Appeal Decision

Appeal Ref: APP/T2350/D/16/3150282

Blue Trees, Manor Road, Copster Green, Lancashire BB1 9EP

- The appeal is made under section 78 of the Town and Country Planning Act 1990 against a refusal to grant planning permission.
 - The appeal is made by Mr J Rowley against the decision of Ribble Valley Borough Council.
 - The application Ref 3/2016/0114, dated 29 January 2016, was refused by notice dated 15 March 2016.
 - The development proposed is erection of garage and boundary fence.
-

Drawing
Proposed Garage and fence details

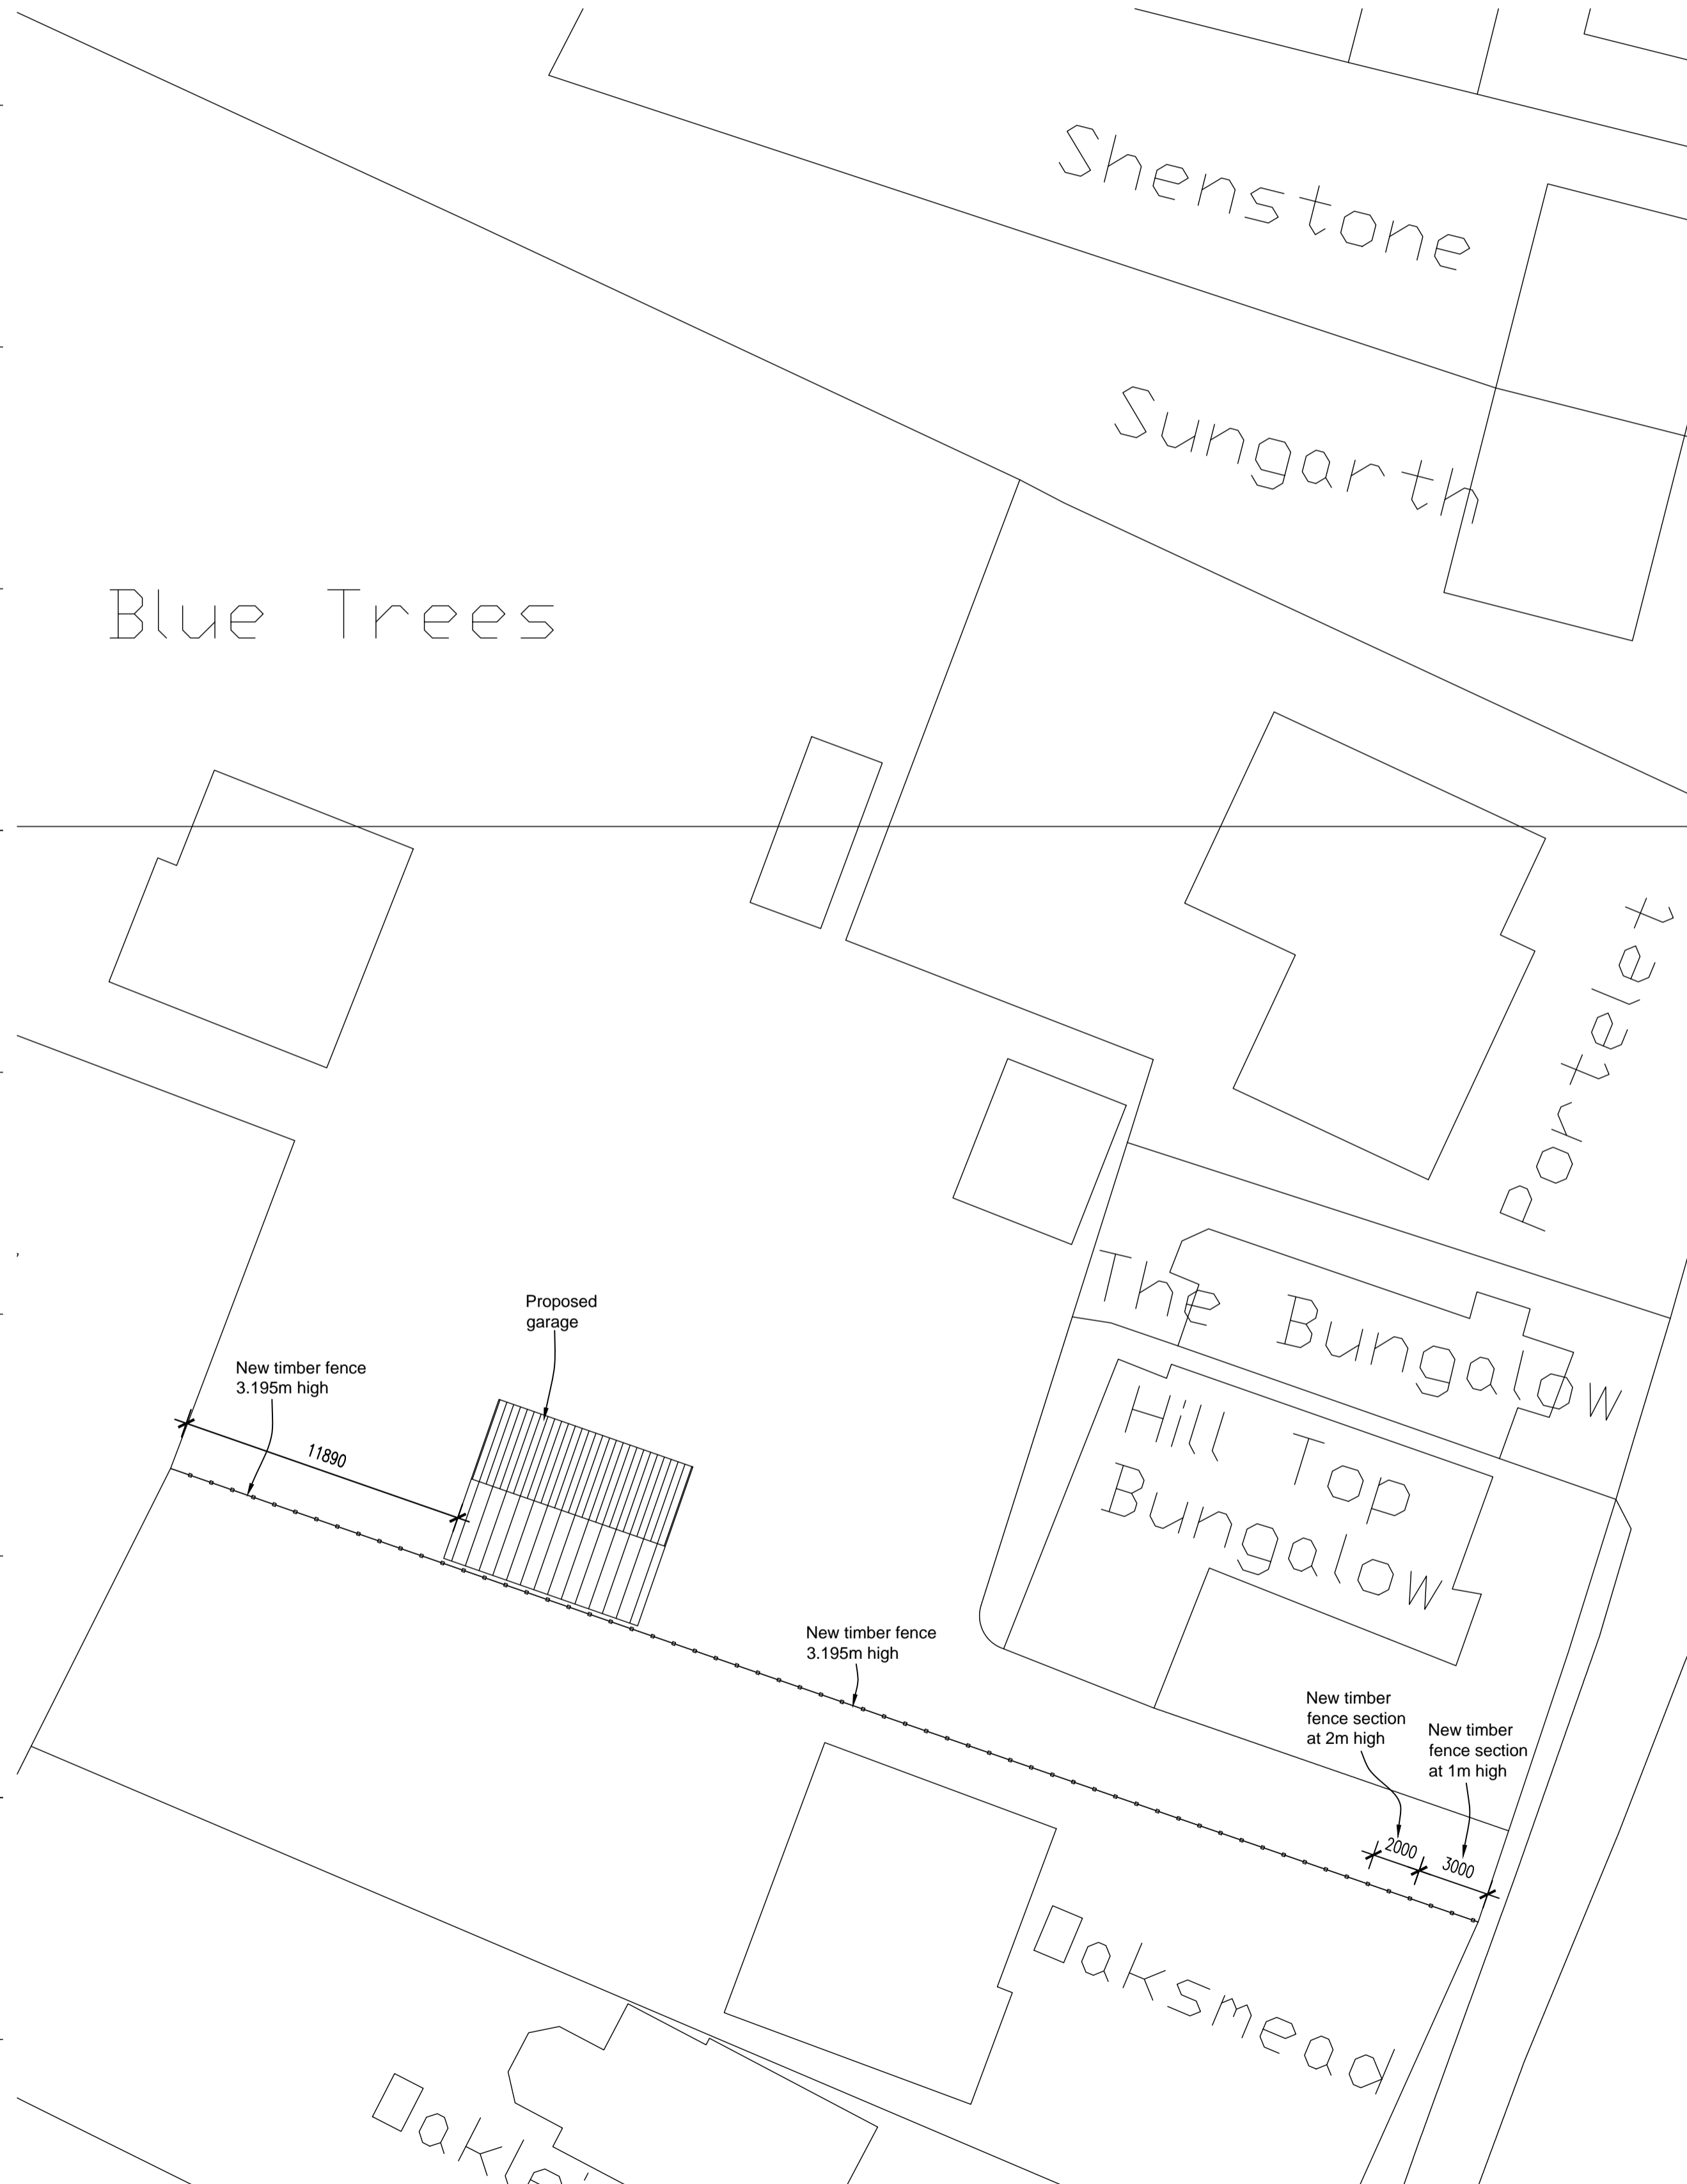
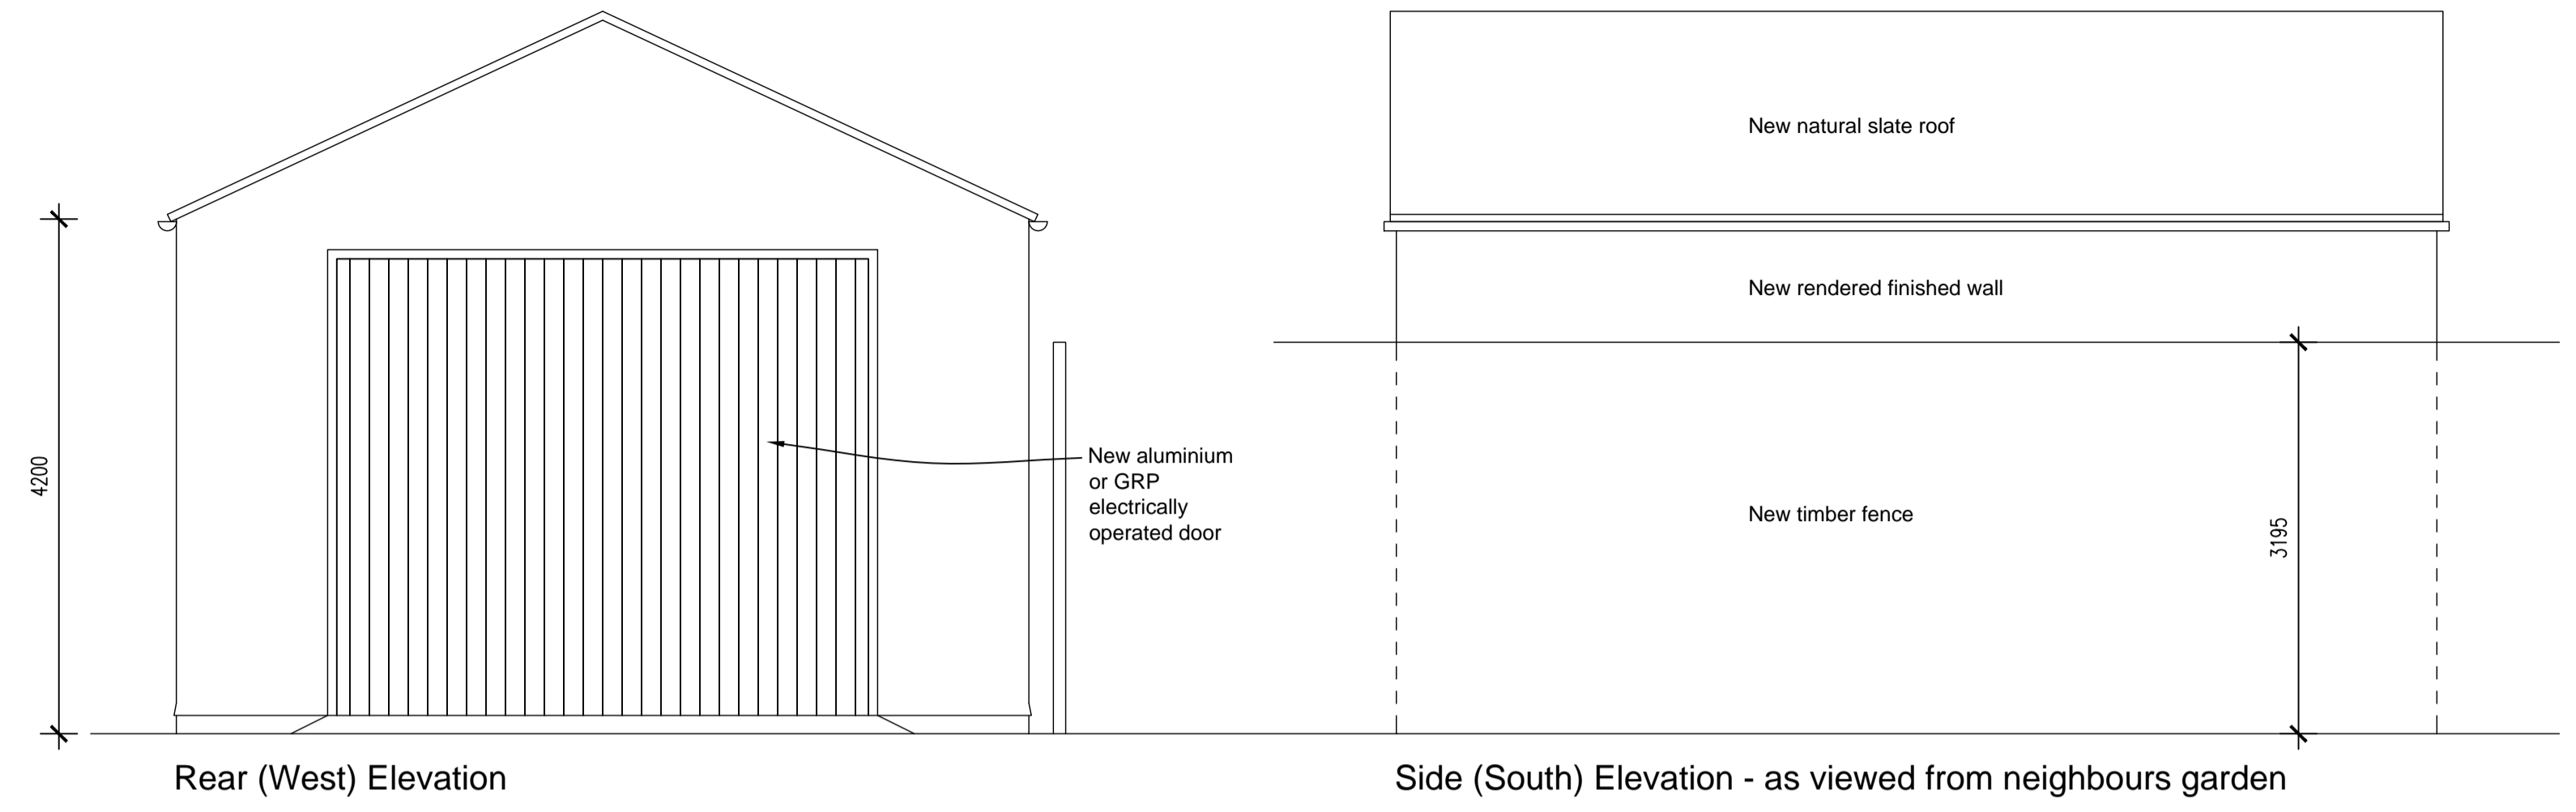
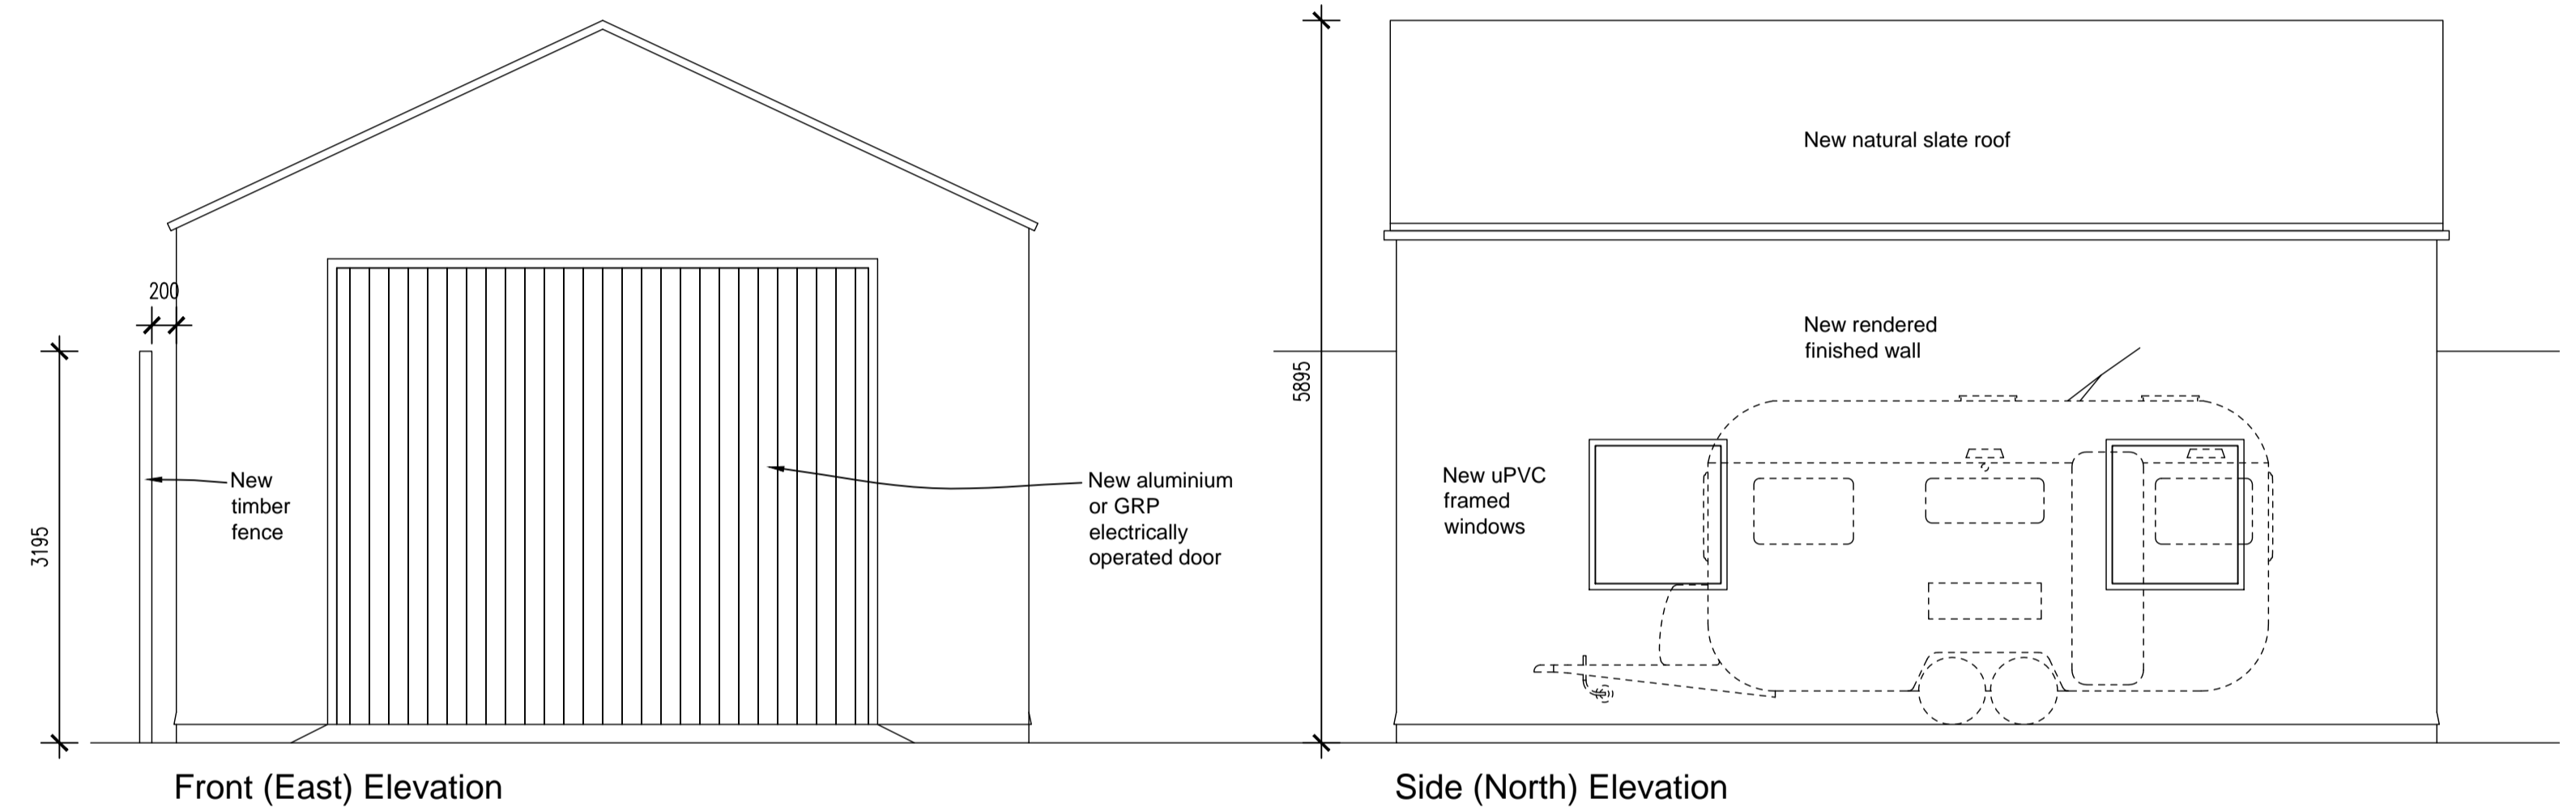
3. The proposed garage would be large and the appellant states that it is required for a caravan / motorhome. It would have large aluminium doors to the front and rear. Whilst it would be set back some distance from the road, it would still be visible especially due to its height. The submitted drawings show dimensions for the building as being 4.2 metres to the eaves and almost 5.9 metres to the ridge. The overall scale of this garage would appear at odds in this location, it would not reflect the semi-rural residential character of Copster Green but would appear incongruous to the area.

4. The fence would run along the boundary with the adjacent dwelling, Oaksmead and for most of its length it would be just under 3.2 metres high. Although it would be lower in height as it neared the road, given the long length and height it would be visually intrusive and out of keeping with the character of the area.
-

6. Although there is a tall hedge along the boundary with Oaksmead the garage would be very close to the boundary. Notwithstanding the hedge, which could easily be reduced in height or removed, given the height and proximity of the garage it would be visually intrusive when viewed from Oaksmead. Likewise the long stretch of fencing proposed along the boundary would be visually intrusive and result in an overbearing impact. However, due the orientation of Oaksmead in relation to the garage and fence, the proposal would not lead to direct overshadowing but this does not lessen the unacceptable impact of the proposal on the living conditions of the occupiers of Oaksmead.
